Ribble Valley Borough Council
Housing & Development Control

Application no: **3/2023/0833**

Address: **Unit 26 Mitton Road Business Park Whalley BB7 9YE**

Proposal: **Application for change of use of part of class B2/B8 unit (general industry/storage) to Sui Generis Mixed Use (retail, warehouse, photo studio, sorting/office). Proposed opening hours Monday - Friday 8.00am - 6.00pm, Saturdays 9.00am to 4.30pm, Sundays and Bank Holidays 10.00am to 4.00pm. Resubmission of application 3/2023/0541.**

6926 -SK02 - REV

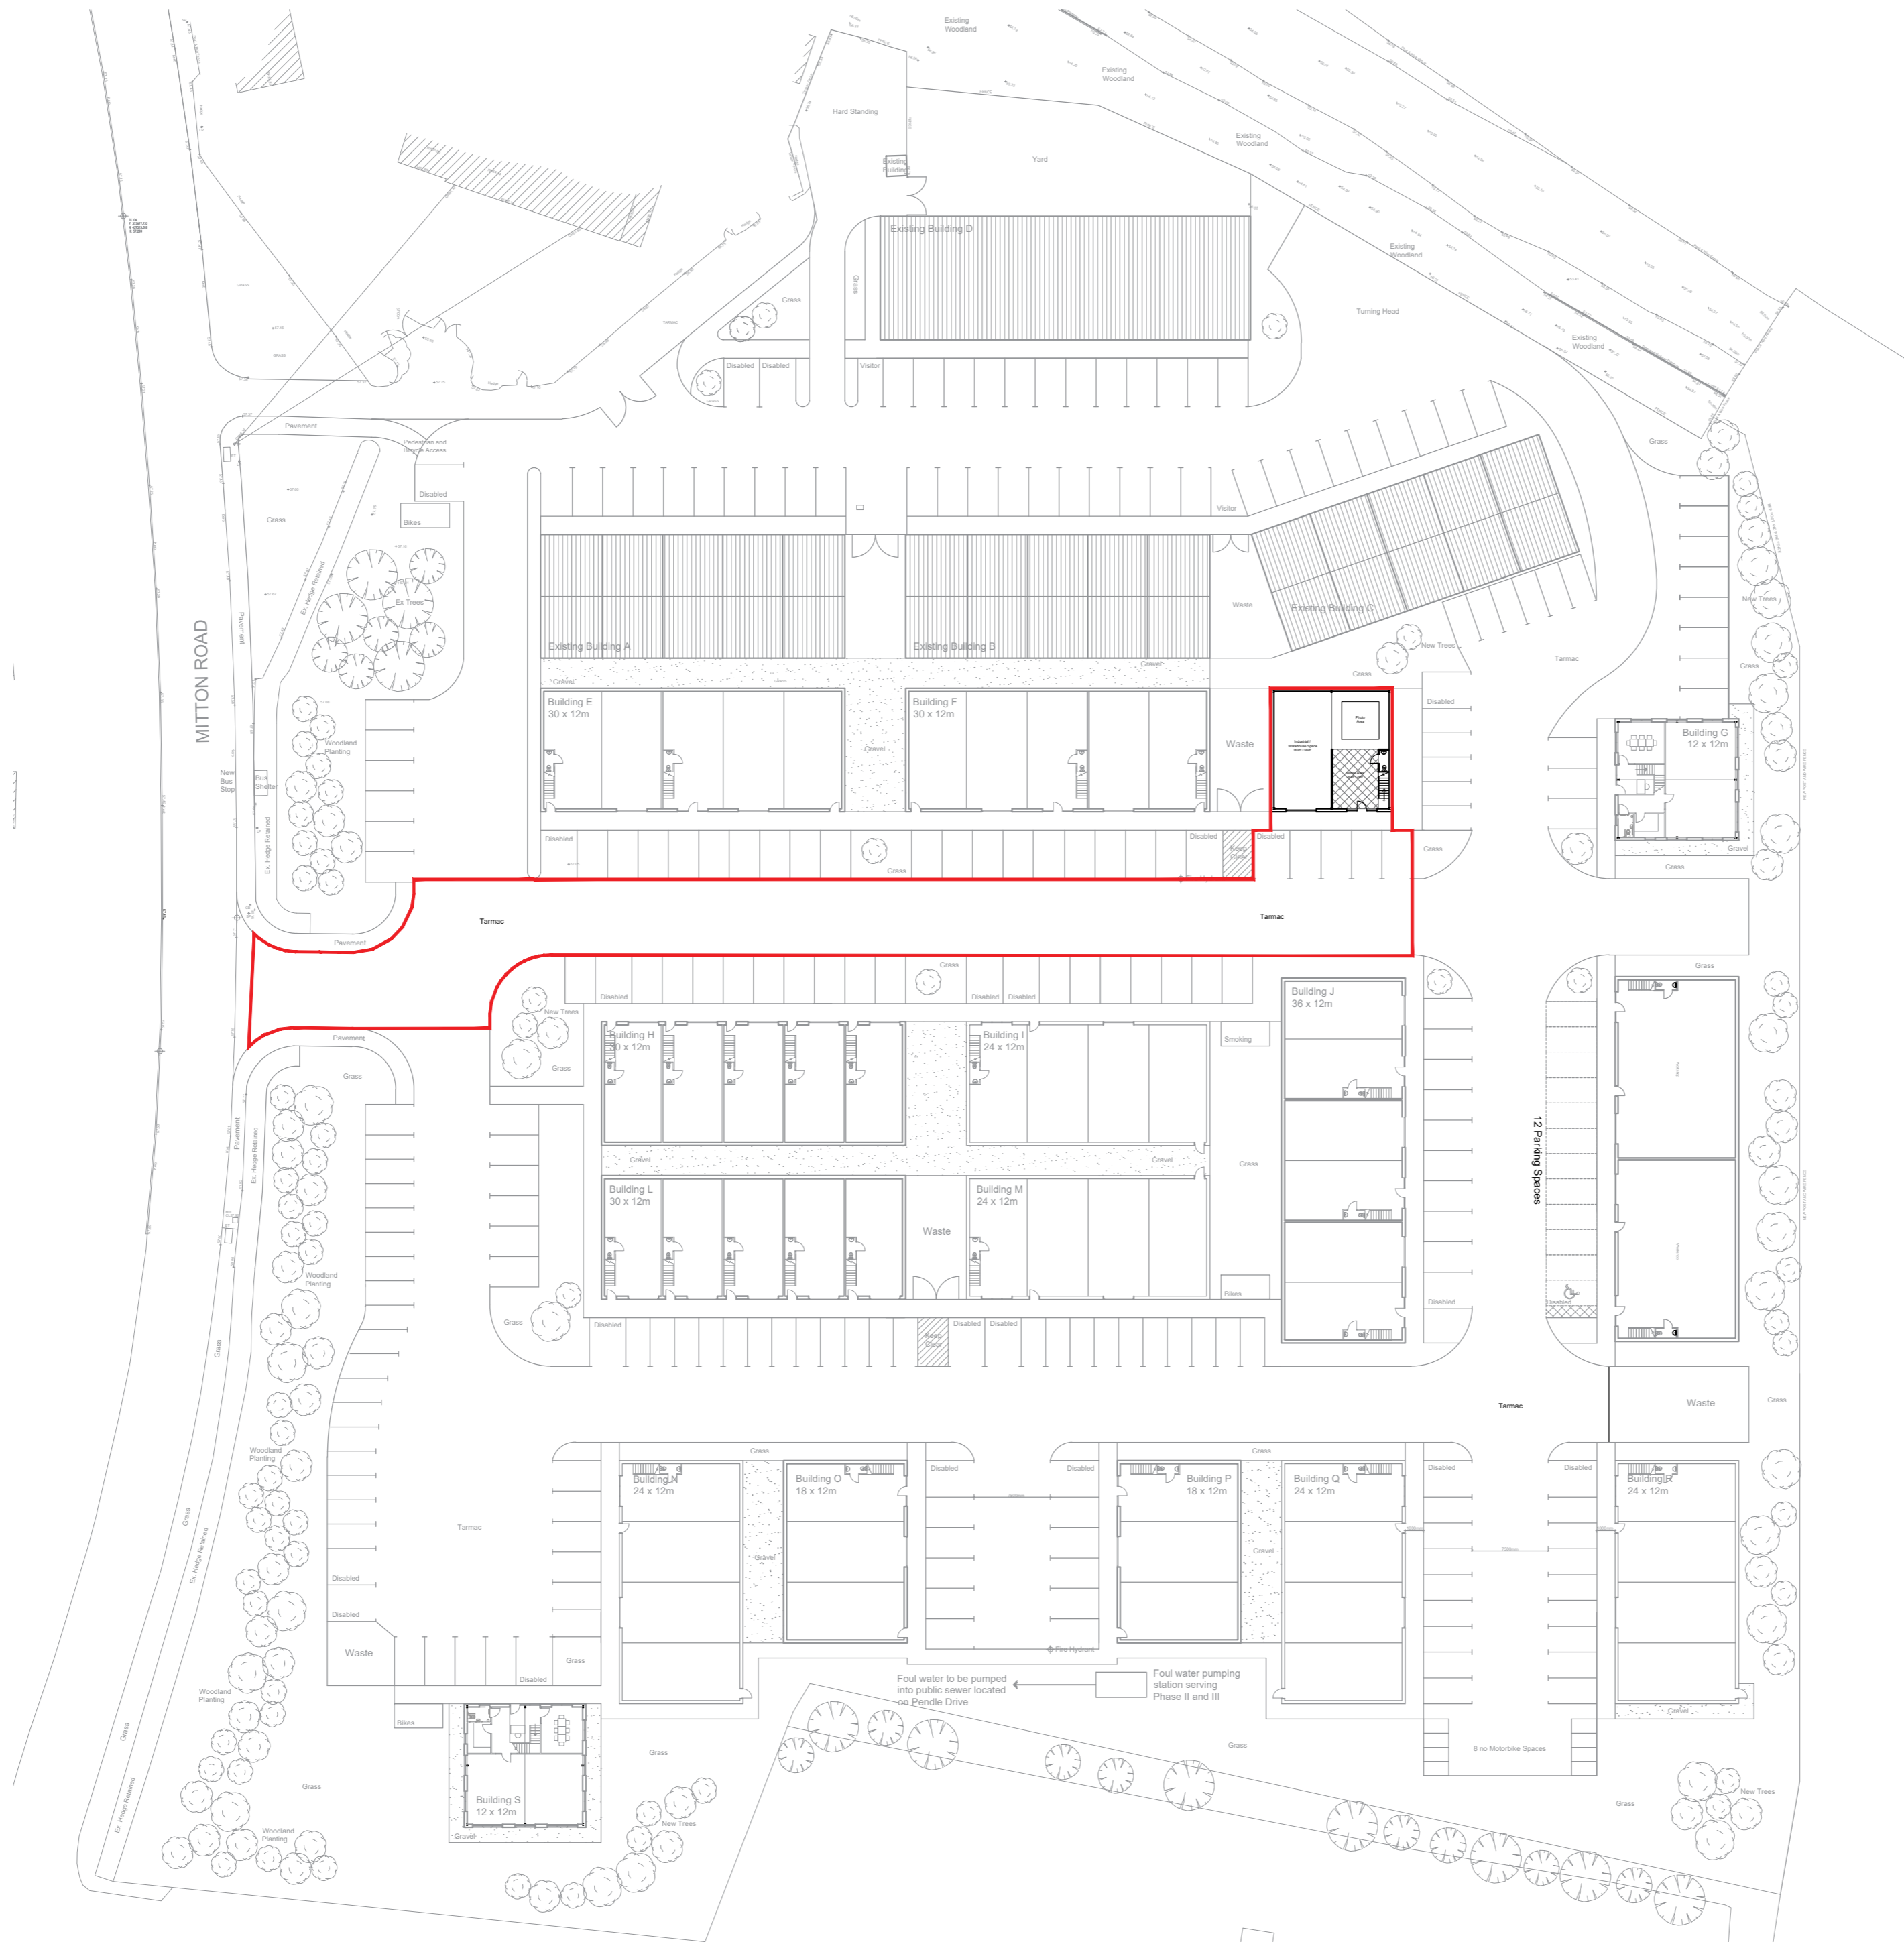
The Agent has provided SPA drawing number 6926-SK02 titled "Proposed Site Plan" which shows that the Unit provides 4 car parking spaces. For the site to comply with the LHAs parking guidance as defined within the Joint Lancashire Structure Plan following the proposal, the LHA require 5 spaces to be provided following the small change of use.

However, the LHA will accept the shortfall in parking. This is because the shortfall is minimal, and the LHA are happy that customer numbers can be controlled by conditions such as the site operating on an appointment only basis for customers. The LHA will also condition that the retail element remains ancillary to the Antique business.

1. The development hereby permitted shall not be occupied until such time as the parking and turning facilities have been implemented in accordance with SPA drawing number 6926-SK02. Thereafter the onsite parking provision shall be so maintained in perpetuity.
